TERRA RIDGE NORTH Pre-Development Grading & Erosion Control Plan El Paso County, Colorado

EL PASO COUNTY PRE-DEVELOPMENT
TERRA RIDGE NORTH
GRADING & EROSION CONTROL
COVER SHEET

C1
SHEET NO.

RURAL LOCAL – PAVED  
 TYPICAL SECTION  
 SCALE N.T.S.

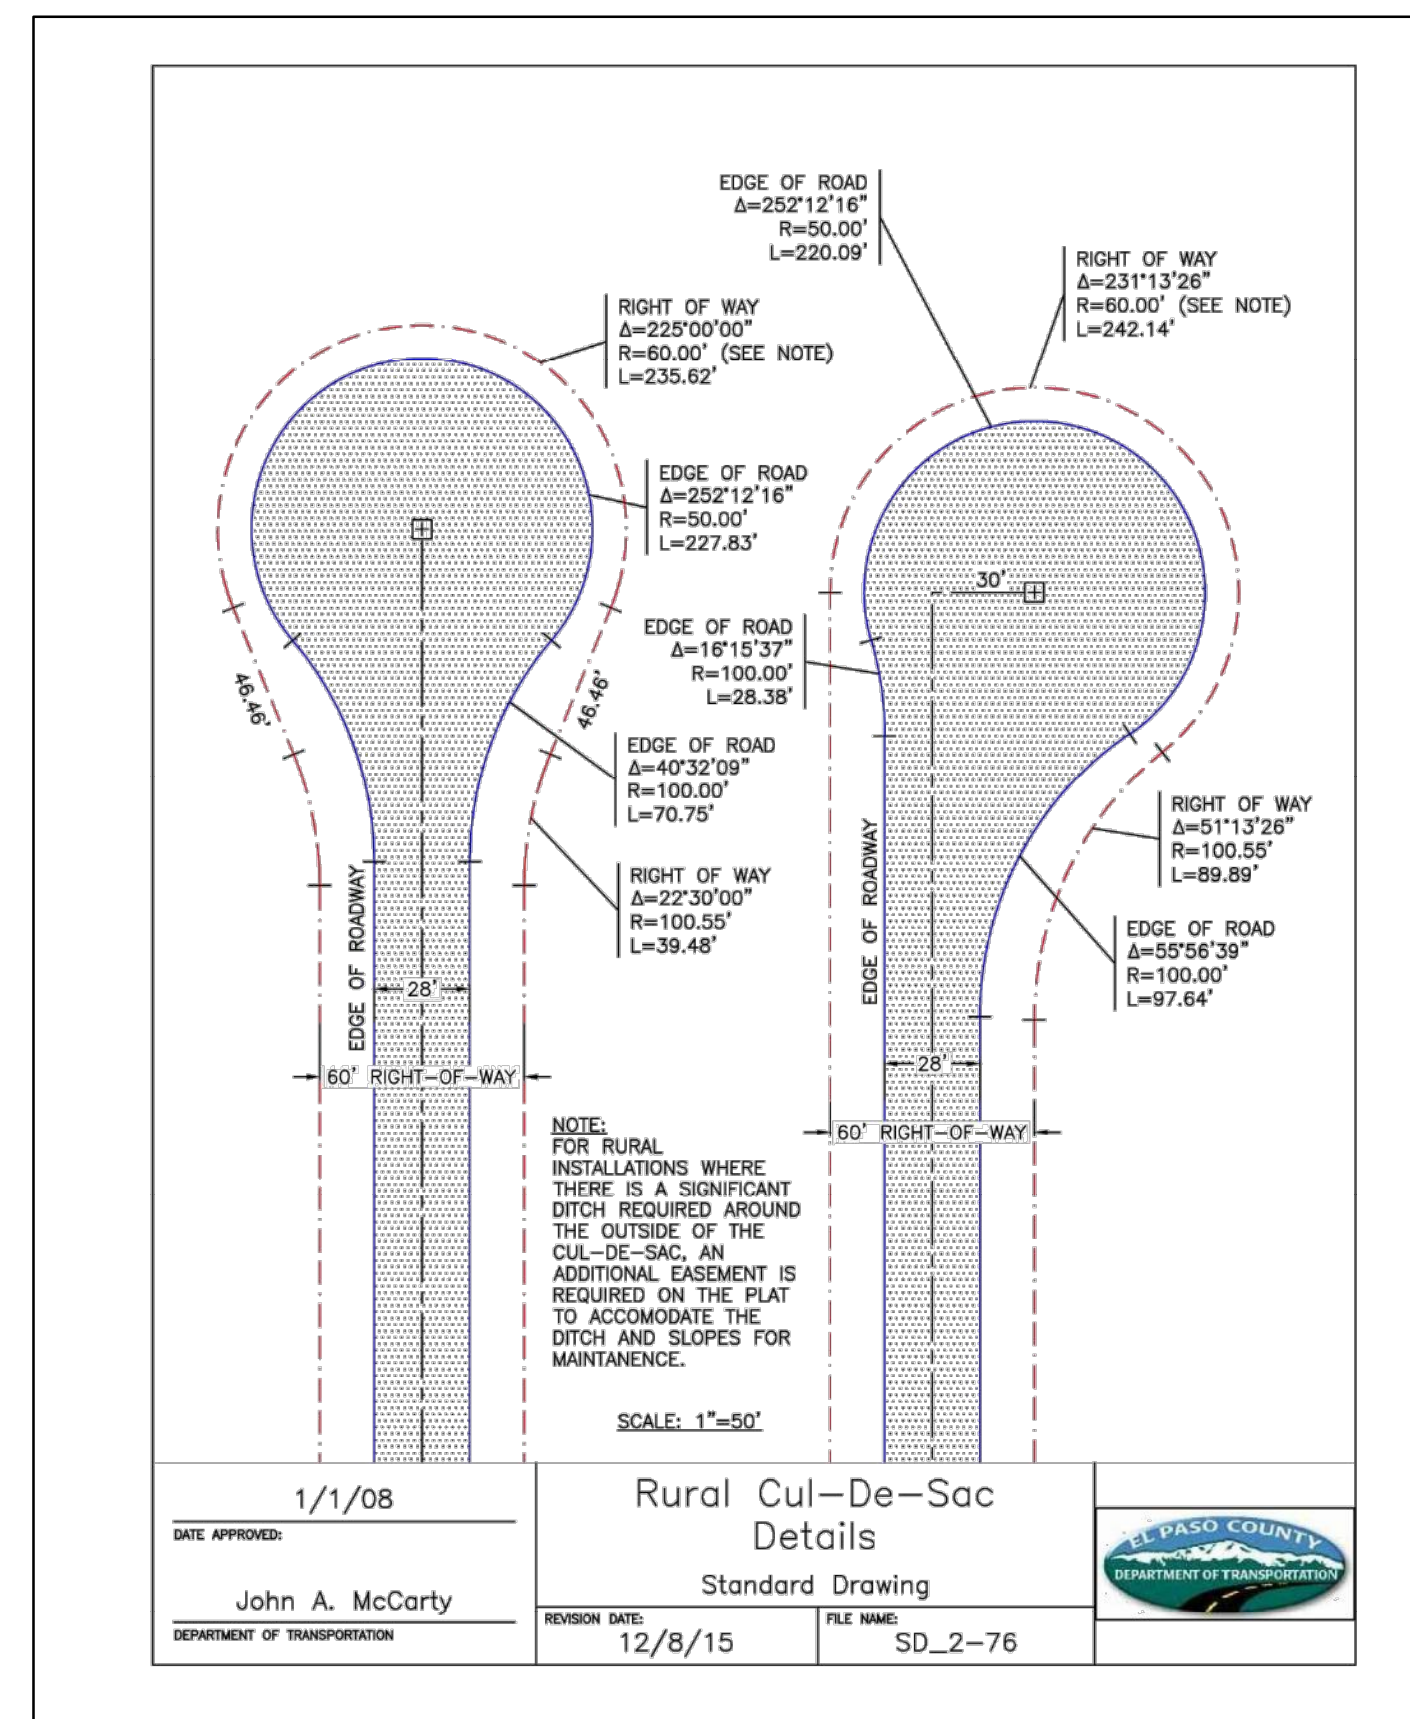
Delete note

Delete note
